Our Ref: BE/92/20/DOC

Approval of details reserved by condition imposed under ref BE/89/19/PL relating to Condition Nos 2 - car parking spaces, 3 - acoustic assessment, 4 - mitigation & remedial strategy for reptiles, 11 - access road, 12 - bat boxes and 13 - dust control

Babsham Business Centre Babsham Lane Bersted PO21 5EL

Arun District Council have decided to **APPROVE details reserved by this condition**

DWG NO	871/PL02	REV. A
---------------	----------	---------------

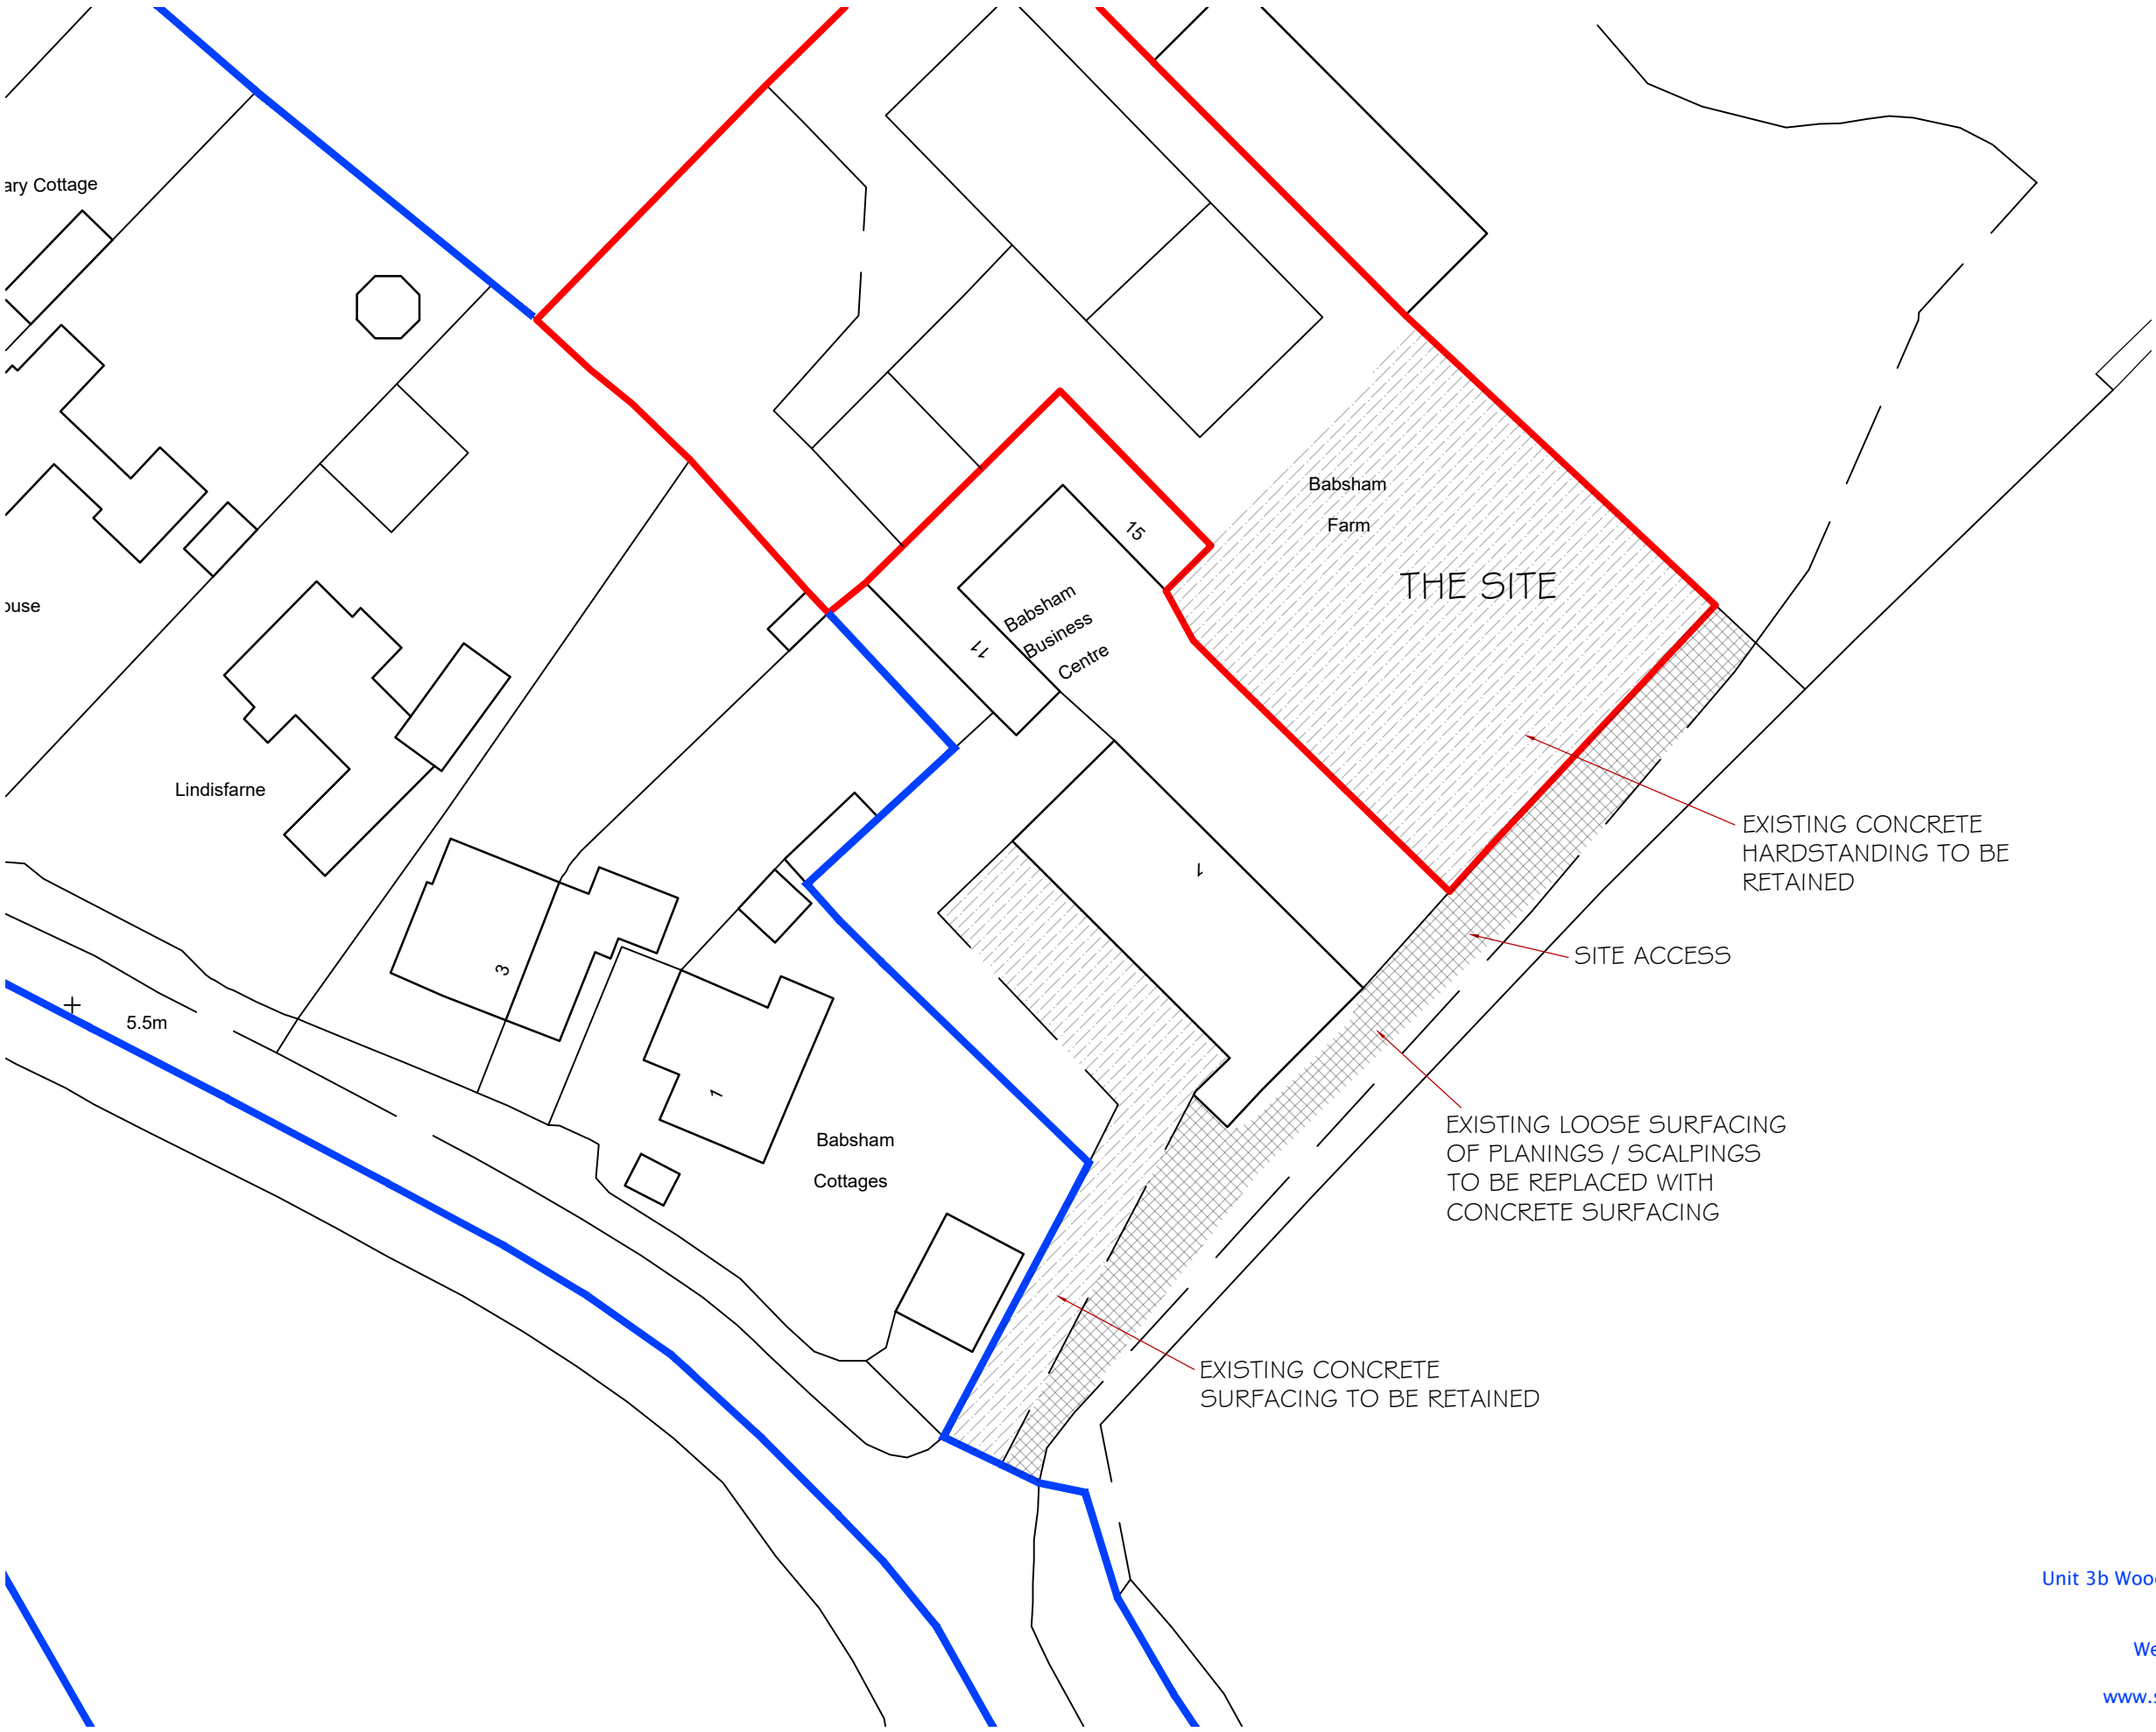
Submitted drawing 871/PL02 Rev A has been appraised by WSCC. The internal access way width will remain the same, but will be constructed from concrete. The applicant may wish to surface the unmade section of the public highway within the access, this would need to be constructed under licence from the Area Office to WSCC standards. The LHA is satisfied that condition 2 can be discharged.

The condition is discharged insofar as the submission of details relates and on the understanding that the approved details will be implemented within 3 month of the approval and the access road shall be

retained in perpetuity. The condition also requires a management plan - no management plan was submitted with the application and therefore a further DOC will be required.
